Subject: RE: Y/105/19/PL and Y/106/19/L

Following our telephone conversation in April and previous email correspondence regarding the planning and listed building application for Stakers Farm Barns, we are intending to make the following amendments to the application to secure a positive determination:

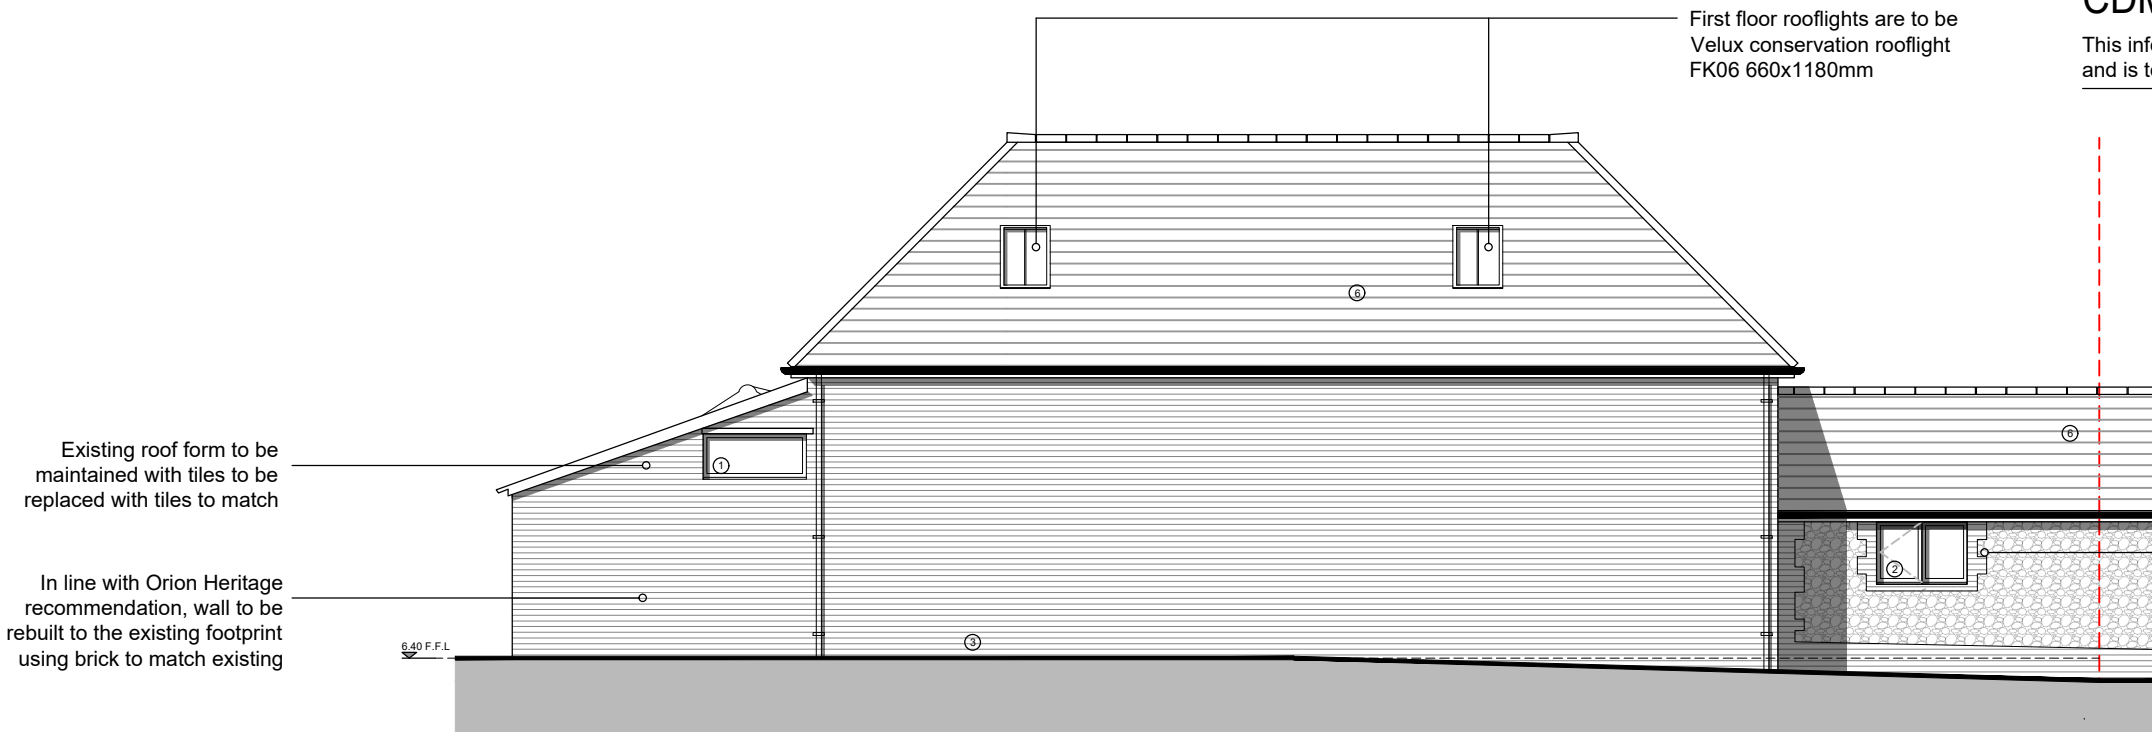
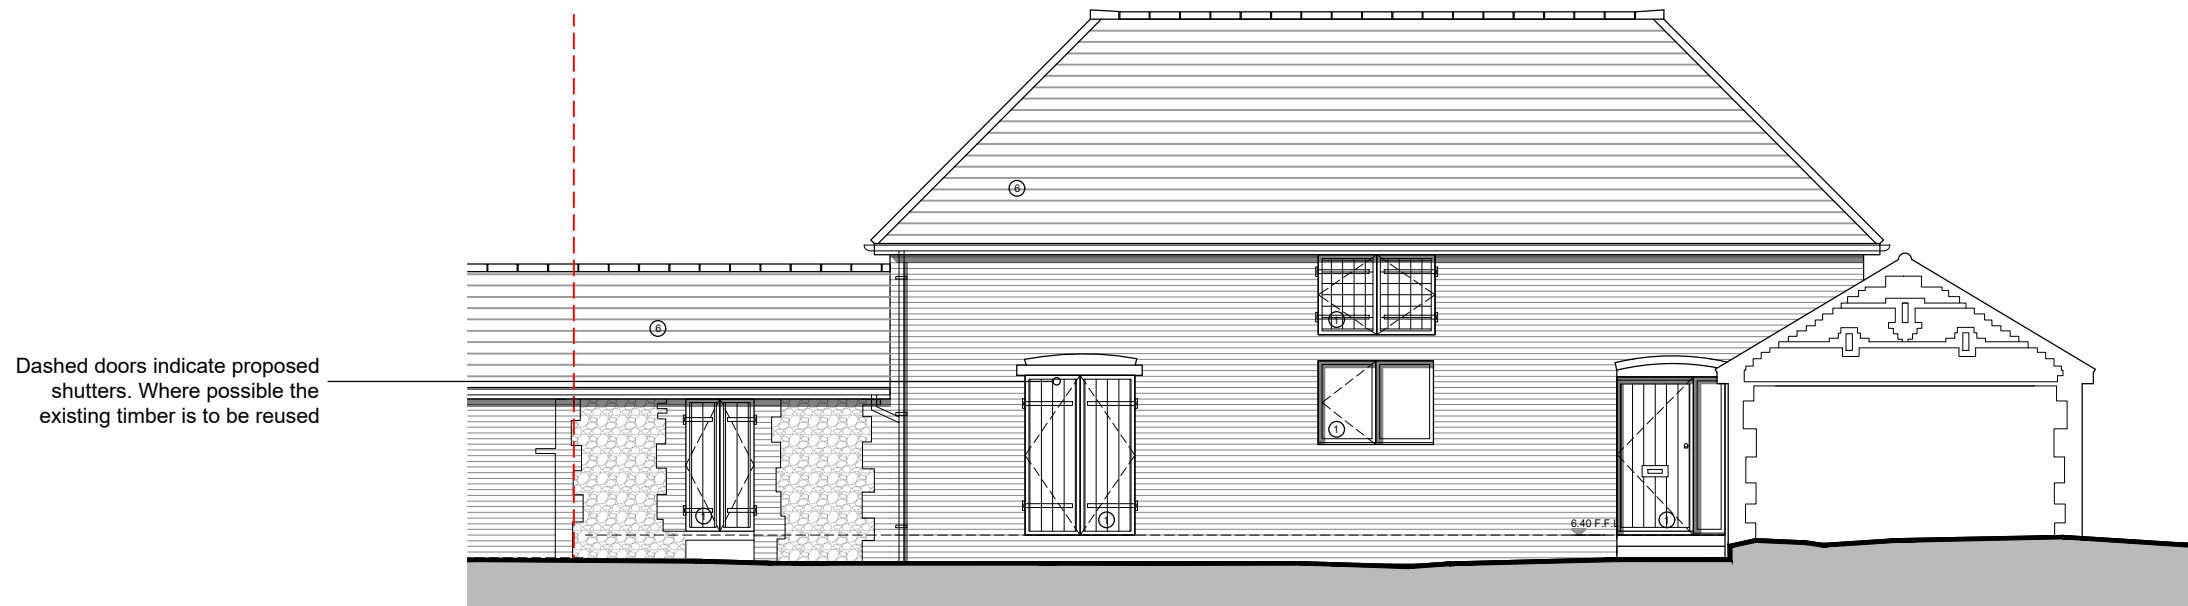
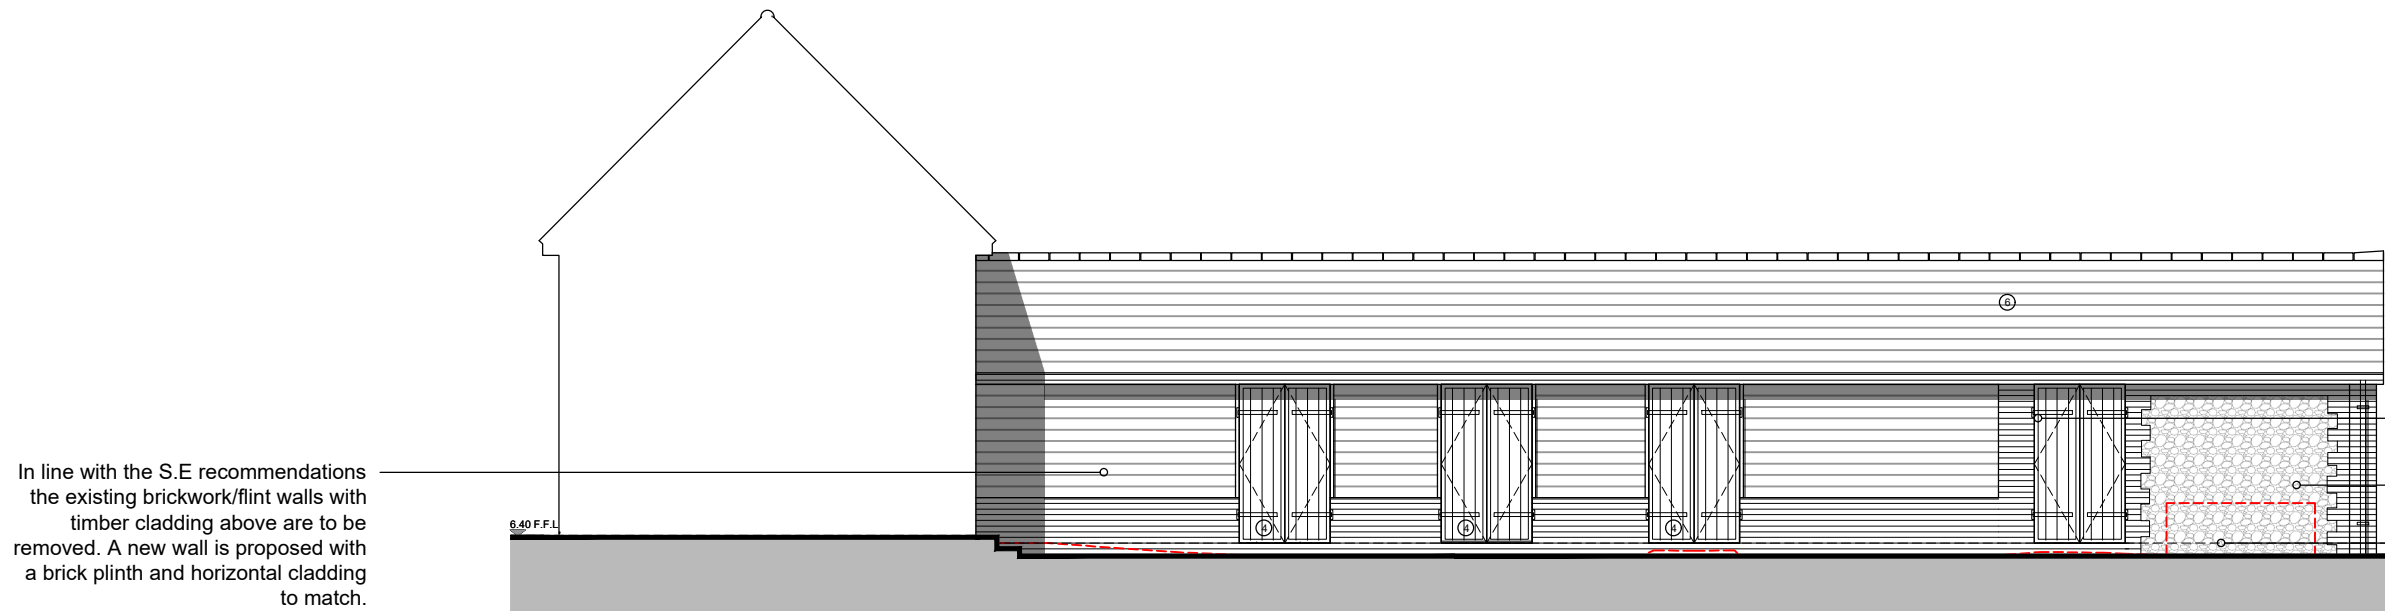
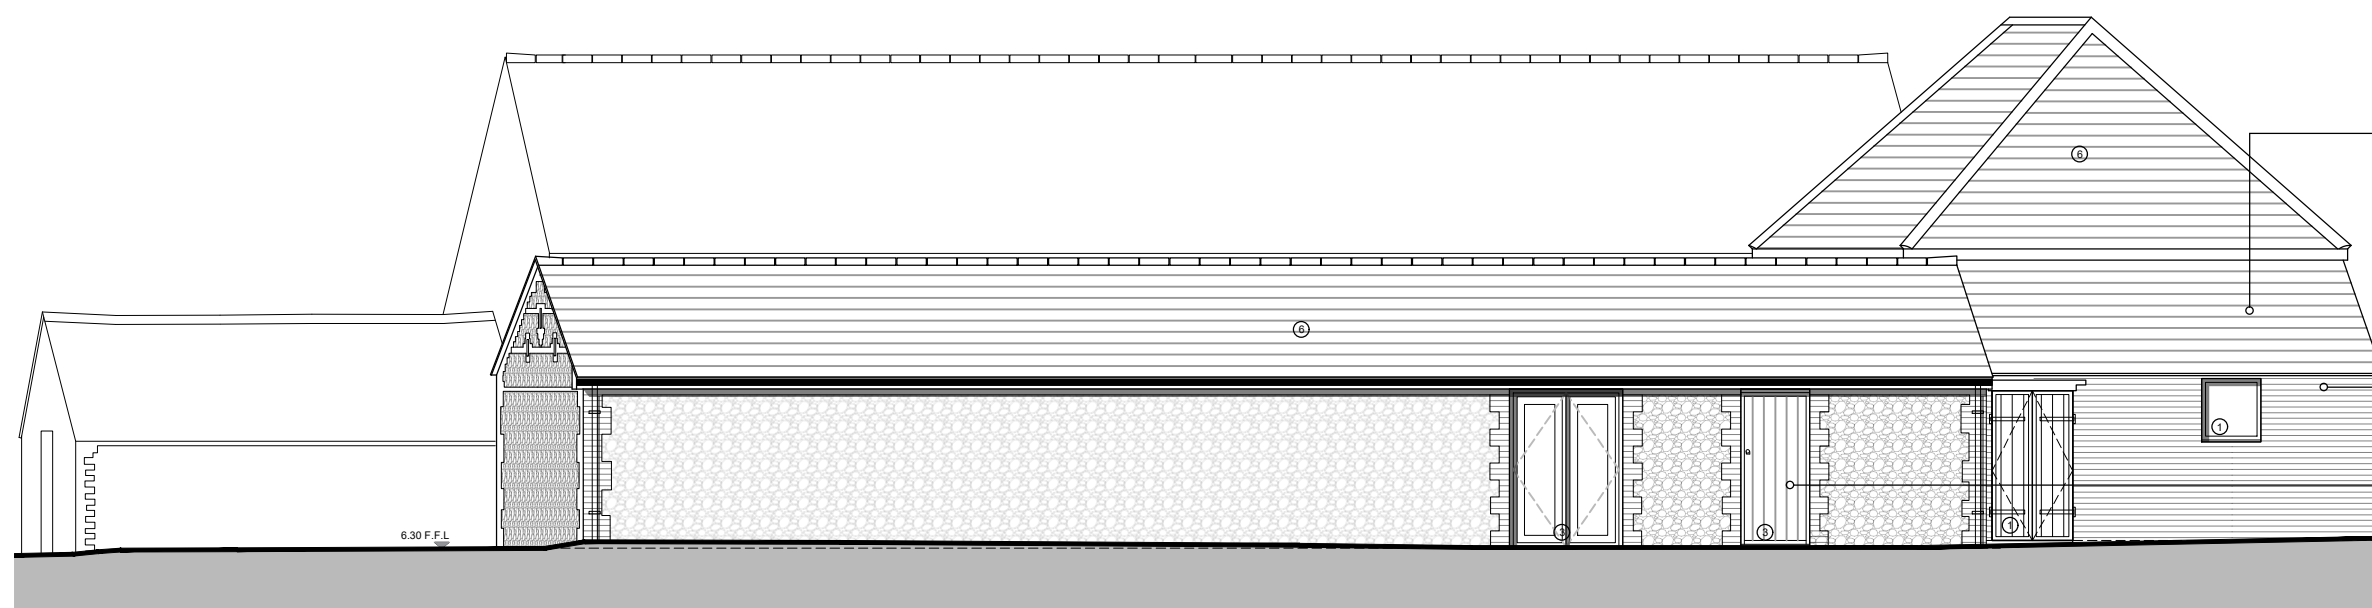
We will remove as many rooflights as possible from this barn. However, we cannot remove all the rooflights as we will need to provide light to the bedroom to make it a habitable space. A roof light will also be required to provide purge ventilation (Part F of Building Regs) otherwise a mechanical system would be needed. Under the Building Regulations we will also need to meet the Daylight and room brightness guidance set within British Standard BS 8206-2:2008 Lighting for Buildings. We will therefore seek to provide the very minimum amount of rooflights necessary to meet Building Regulations and seek to locate them on the least prominent part of the roof.

South elevation – we will amend the proposed alterations to the single storey element and reduce the amount of glazing, ensuring that this elevation is changed as little as possible from the existing situation.

Proposed North Elevation (D)

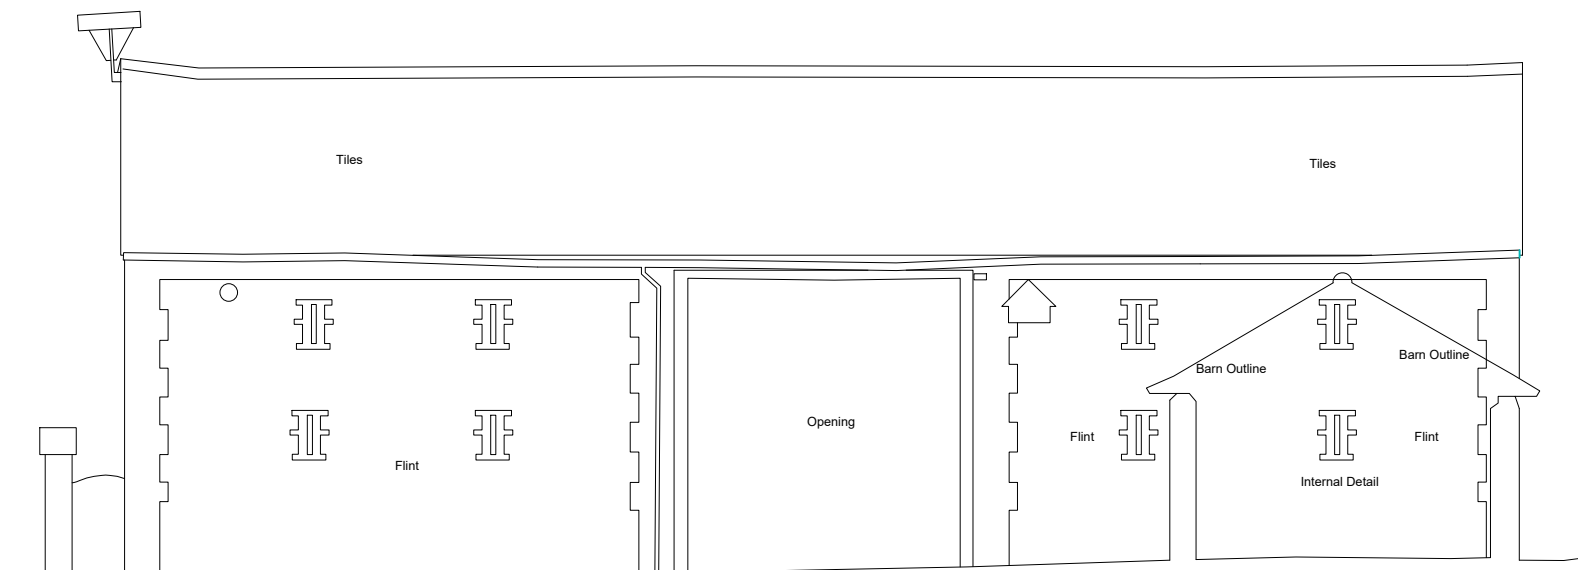
North elevation – we will reduce the number of rooflights as agreed

Proposed East Elevation (B)

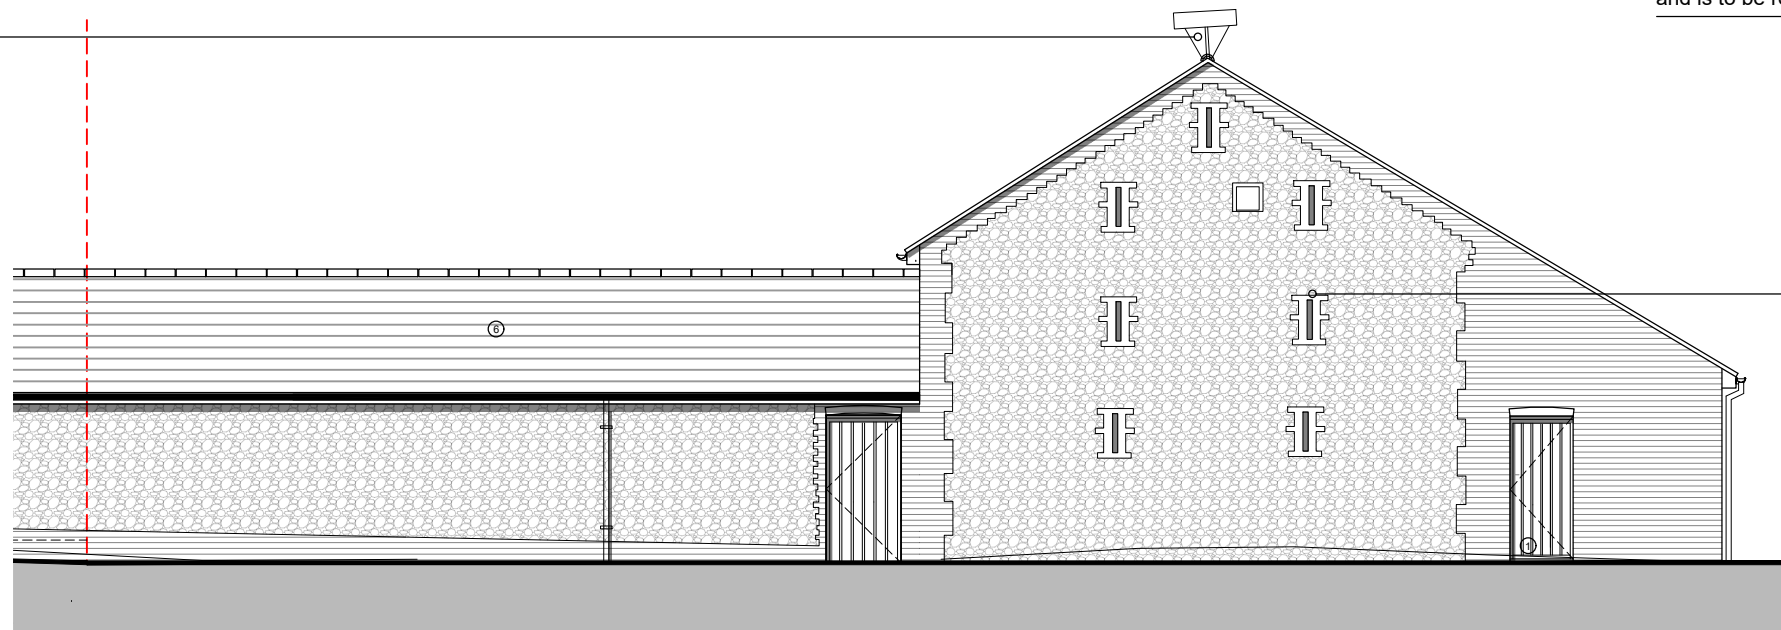
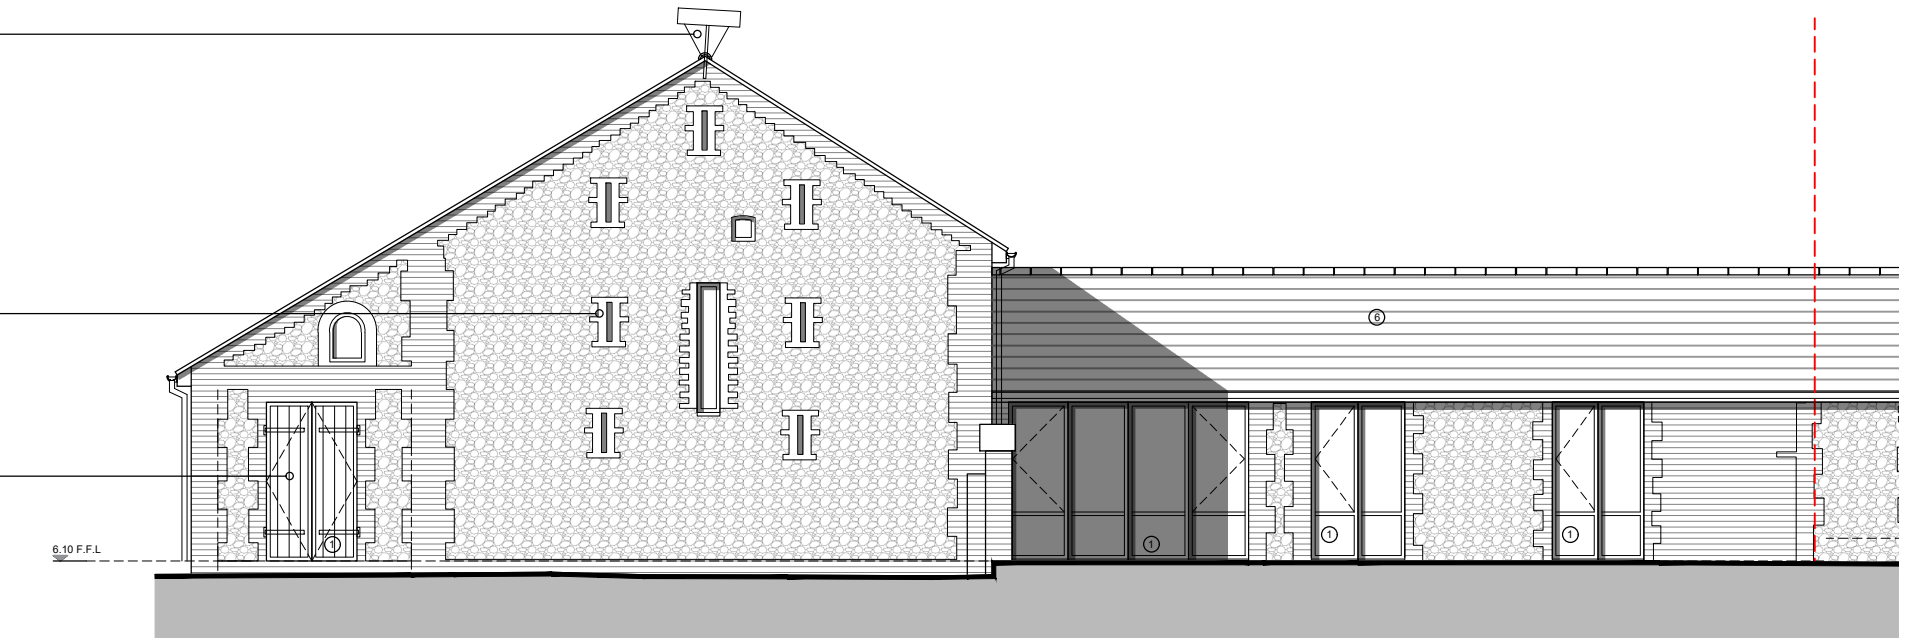
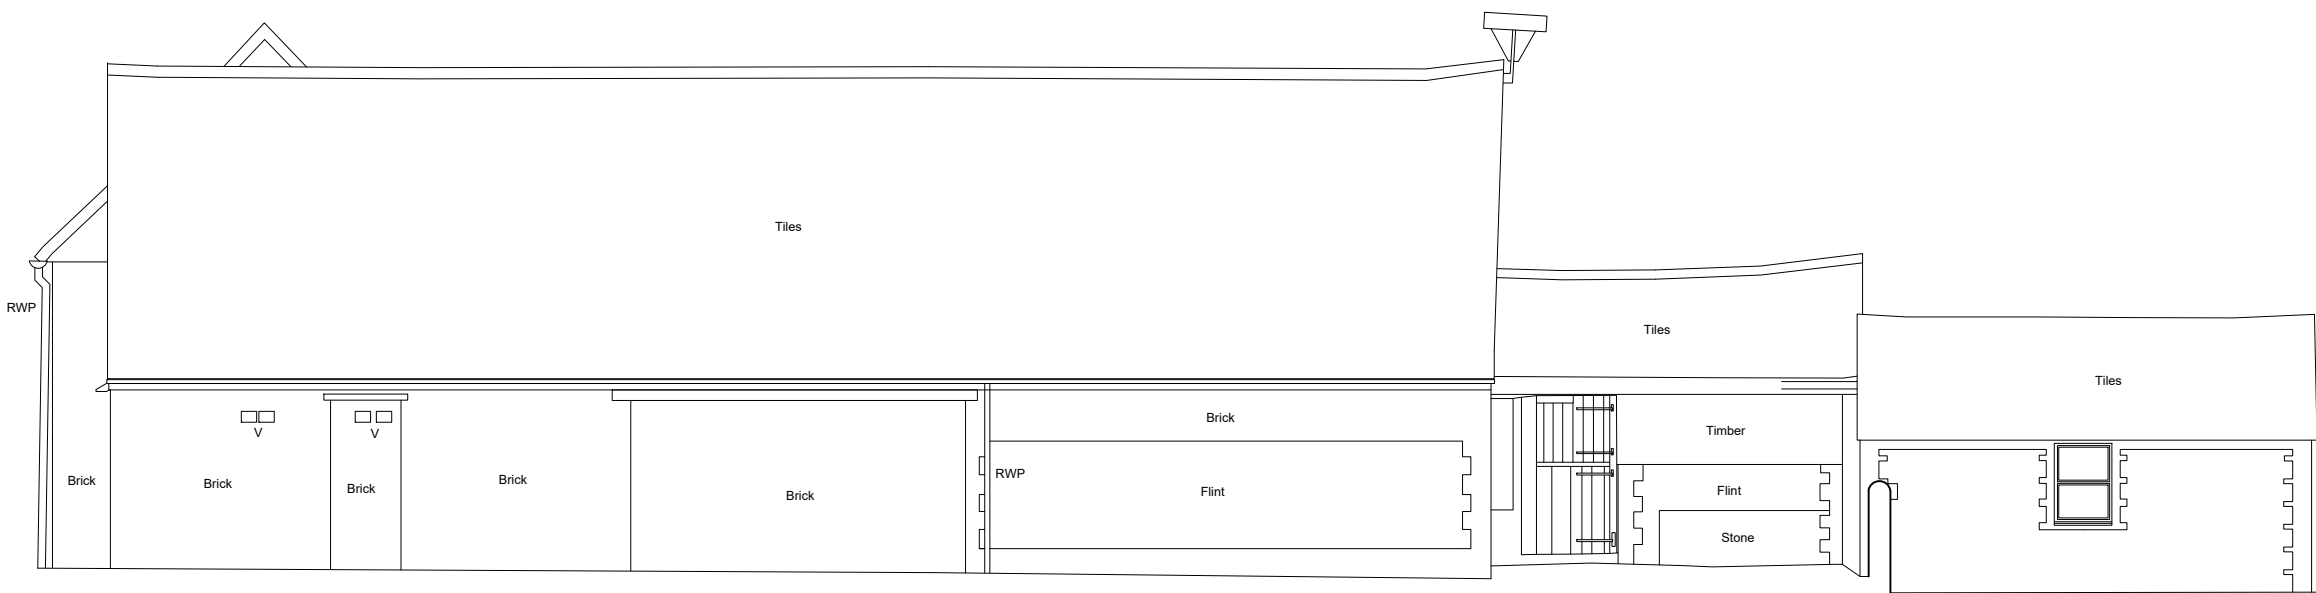
East elevation – we will ensure that the single storey element of the barn retains the features of the existing building as far as possible and will not reduce in size the larger existing opening.

East elevation – having regard to the two storey part of the barn, as discussed, we will have a look at how we can improve that part of the barn that was rebuilt at a later date and we will replace the existing unsympathetic door.

South elevation – we will remove all of the lower rooflights but will keep the higher ones. We will also reconsider the French doors.

North-west elevation – we will seek to retain the small existing window by the door and retain the existing door in the single storey element rather than installing a new door.
